**From:** Michael Eastham <Michael.Eastham@arun.gov.uk>  
**Sent:** 04 December 2020 14:25  
**To:** Planning.Responses <Planning.Responses@arun.gov.uk>  
**Subject:** FW: \*EXTERNAL: A/179/20/RES - Land South of Water Lane, Angmering

Please upload onto Ocella the email below which is a further consultation response from the **Local Highway Authority** raising no objection to the reserved matters application (A/179/20/RES) for the culverted embankment on Land South of Water Lane, Angmering.

Please see the email below from Sean Havis at BDW and find attached an amended plan for reserved matters application **A/179/20/RES** relating to the culverted embankment on Land South of Water Lane, Angmering.

WATER LANE, ANGMERING
PROPOSED ACCESS
VEHICLE SWEEP PATH ANALYSIS
DUO RECYCLER

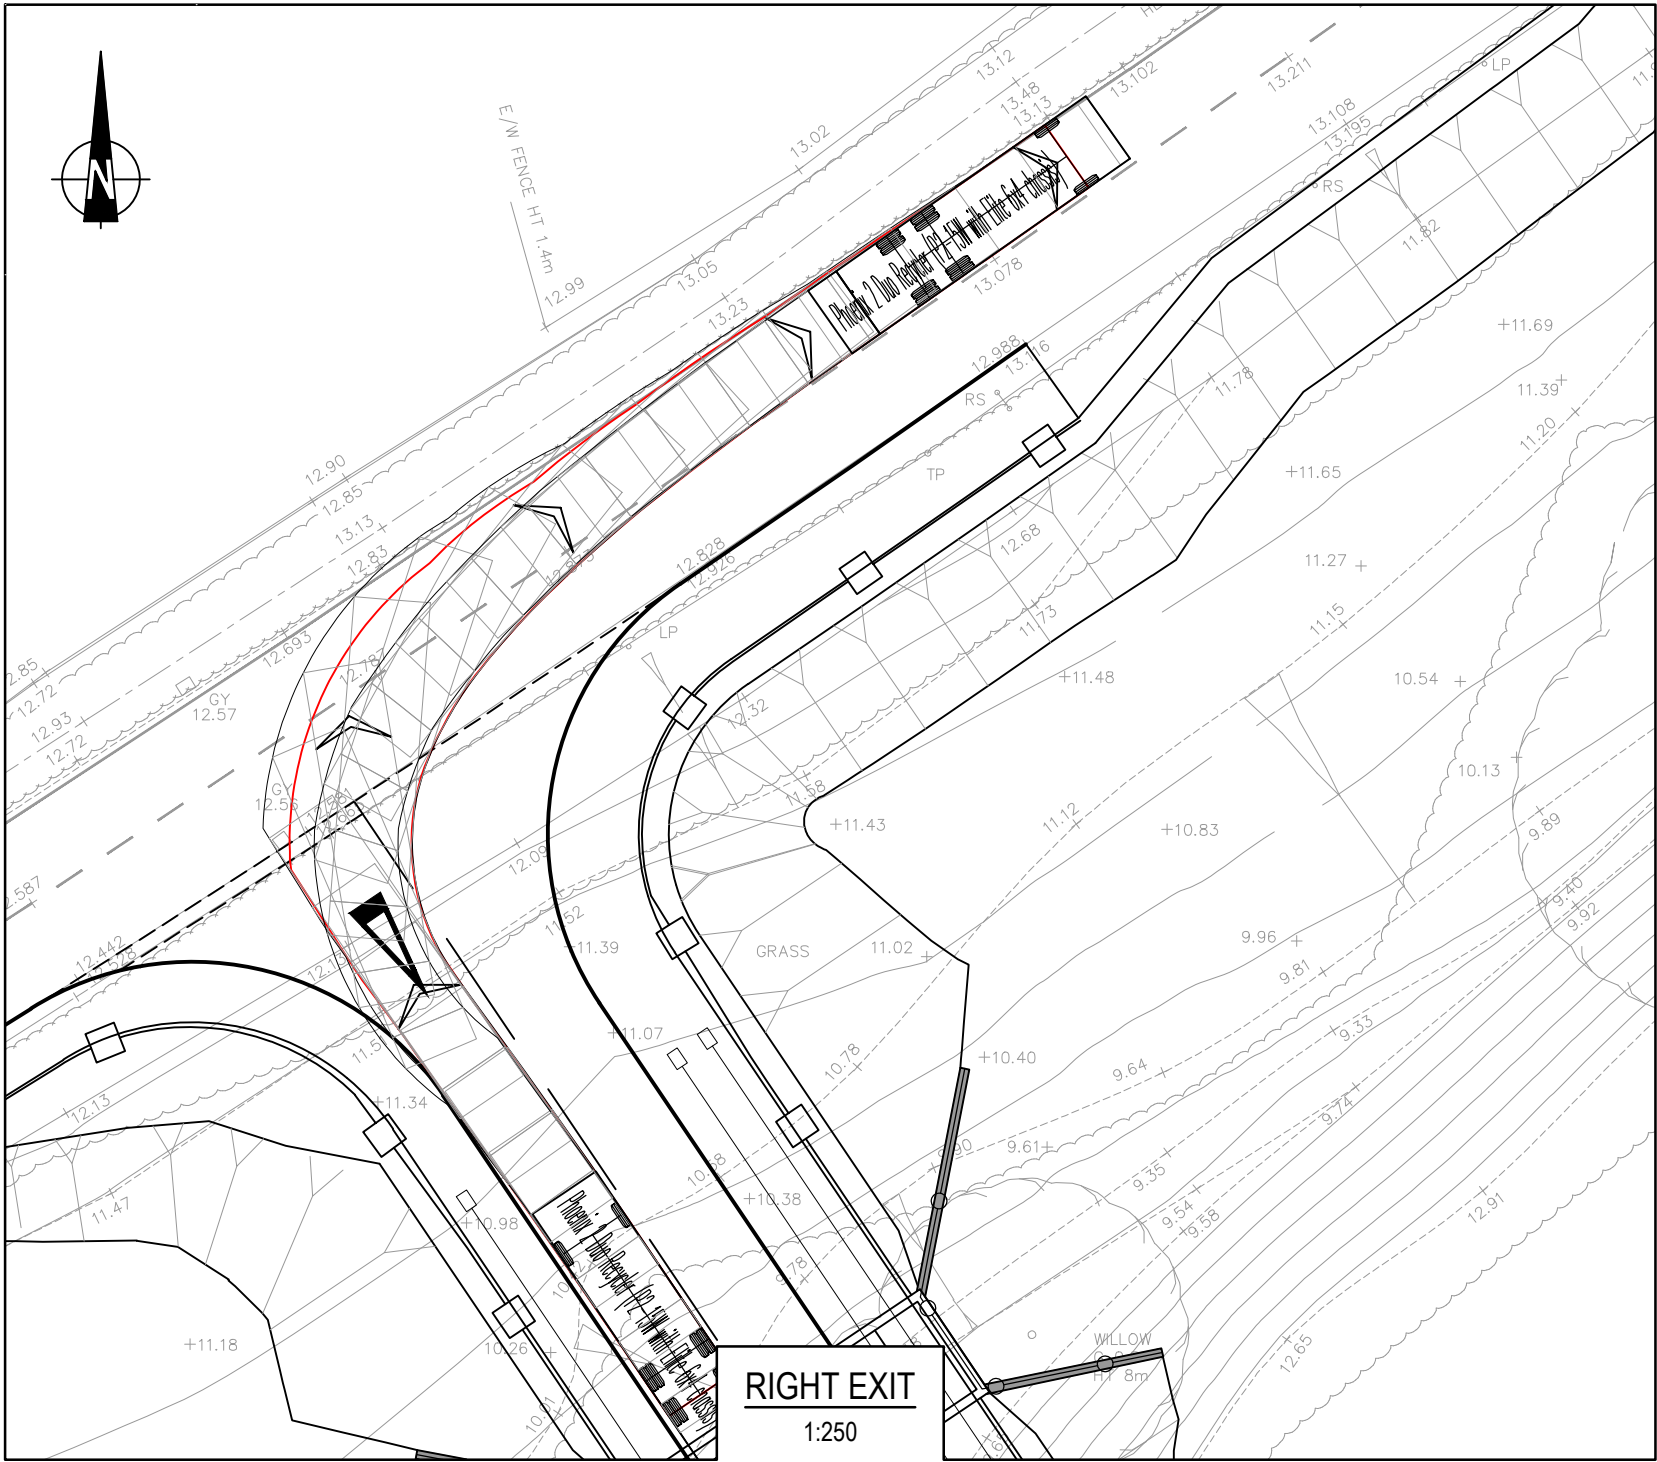
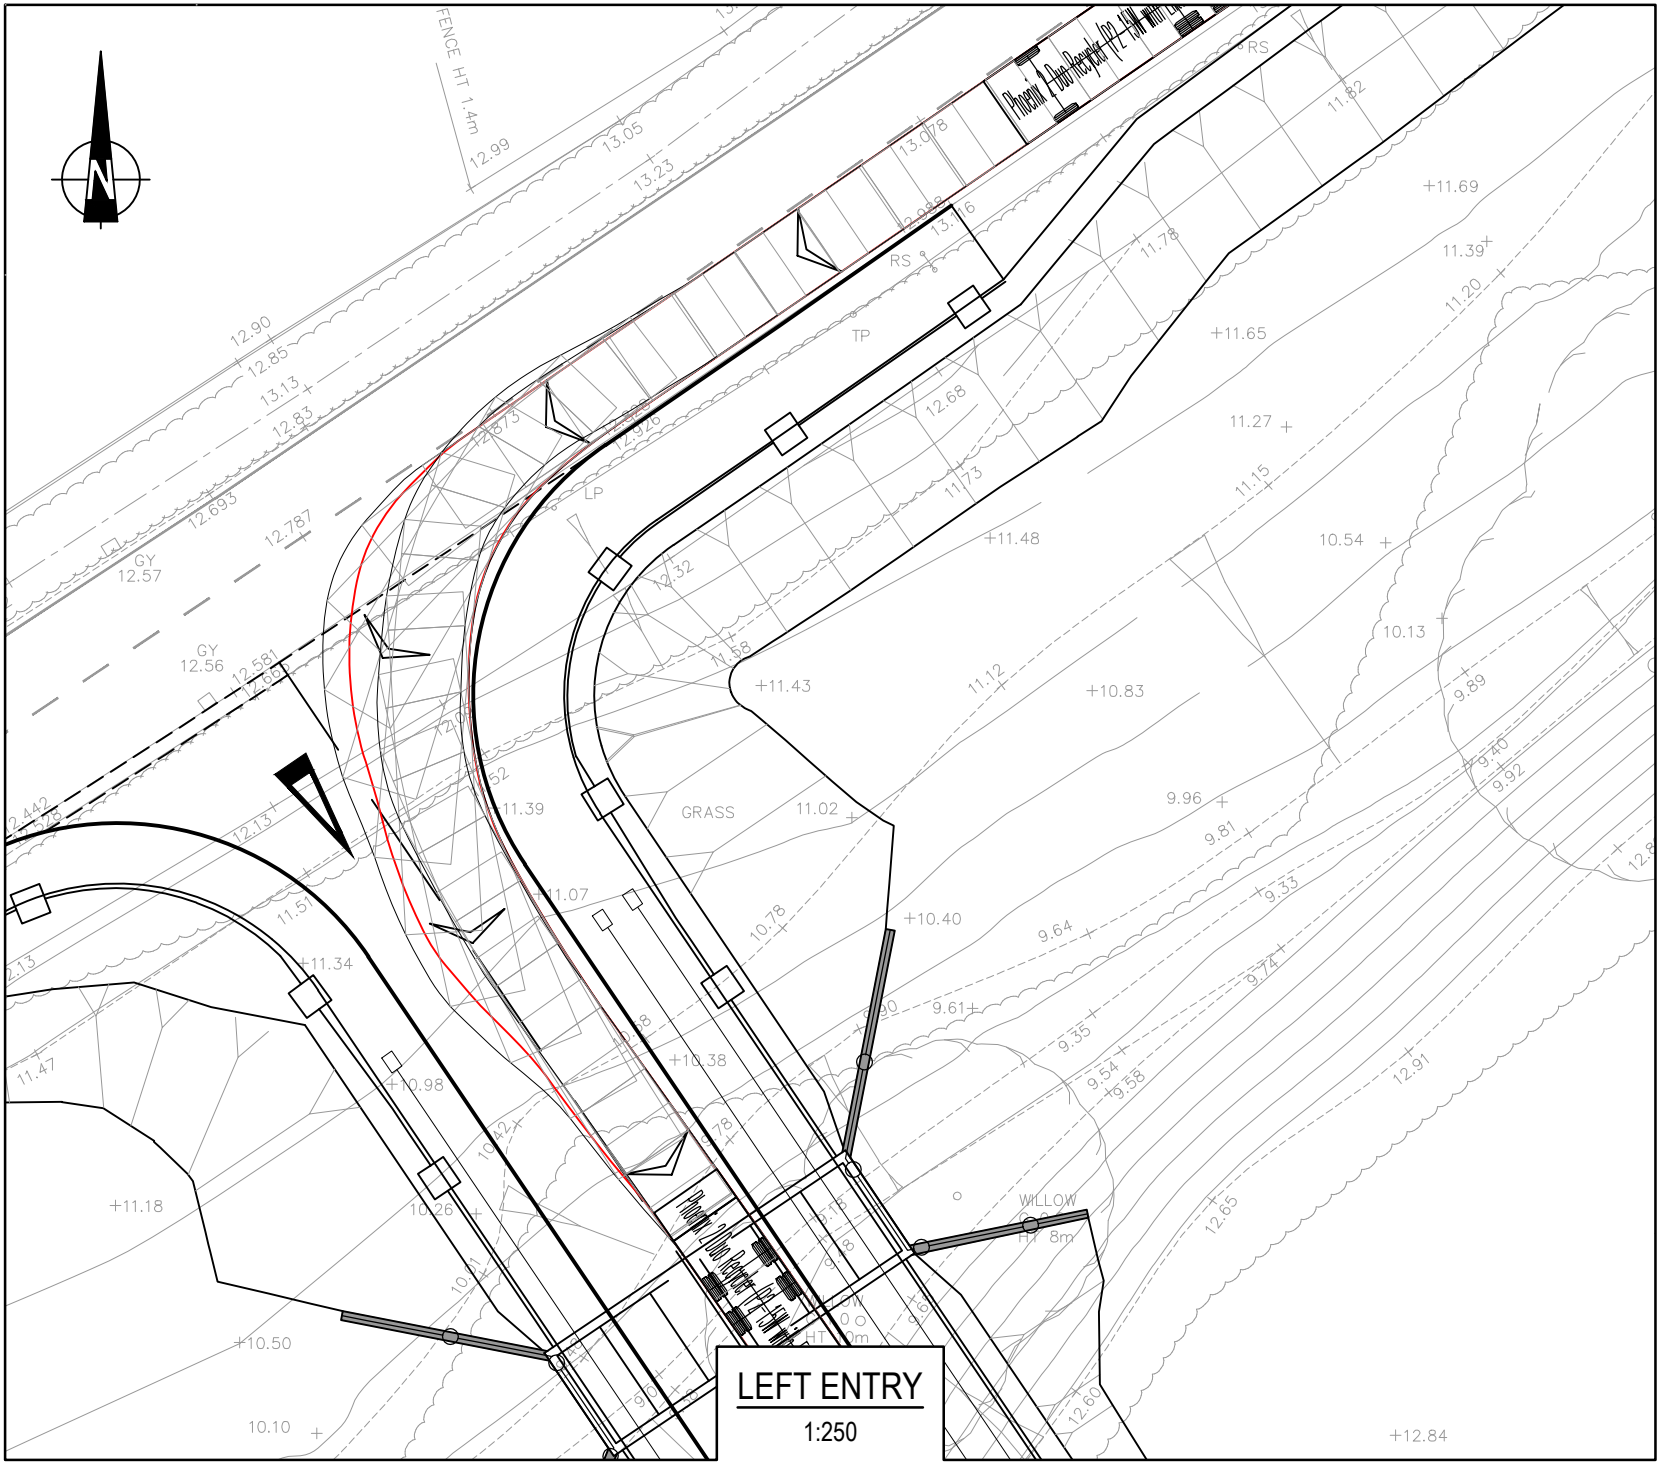
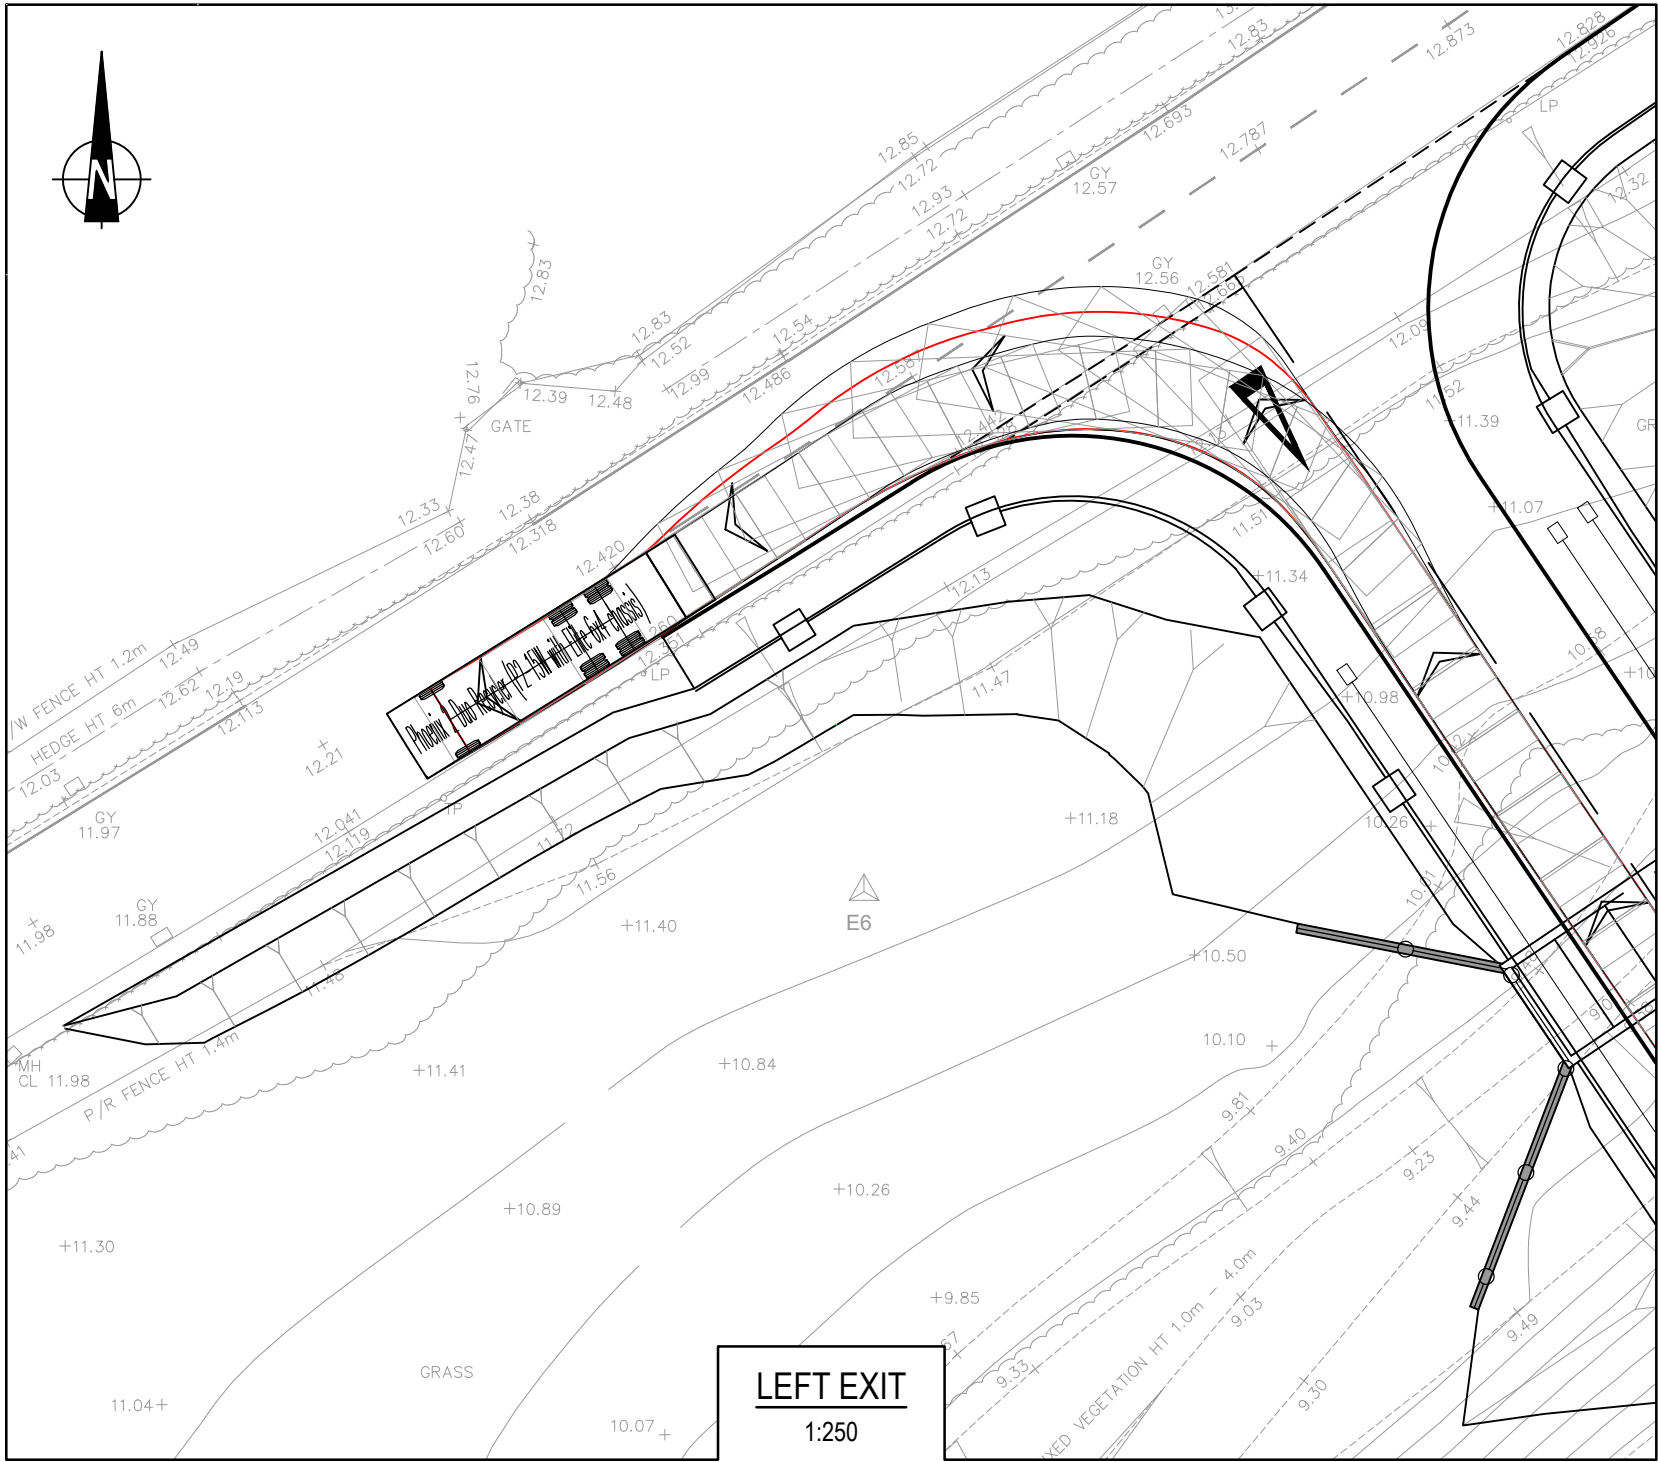
Evidence would be required that there is sufficient access width for a fire appliance to access the site. The road would need to be sufficiently wide enough to allow a fire appliance to gain access with a minimum width of 3.7 metres and capable of withstanding 12 to 17 tonne axial weight.

In regard to the other two queries from the Local Highway Authority and WSCC Fire & Rescue Service, please find the attached revised plan (General Arrangement - 46353\_2002\_020\_A) illustrating the crossing over Water Lane connecting into the footway/cycleway running north and east. The attached plan also demonstrates that the width of the carriageway is 6m, significantly exceeding the 3.7m requirement. I can also confirm that the culvert will be constructed to be capable of withstanding 12 to 17 tonne axial weight.
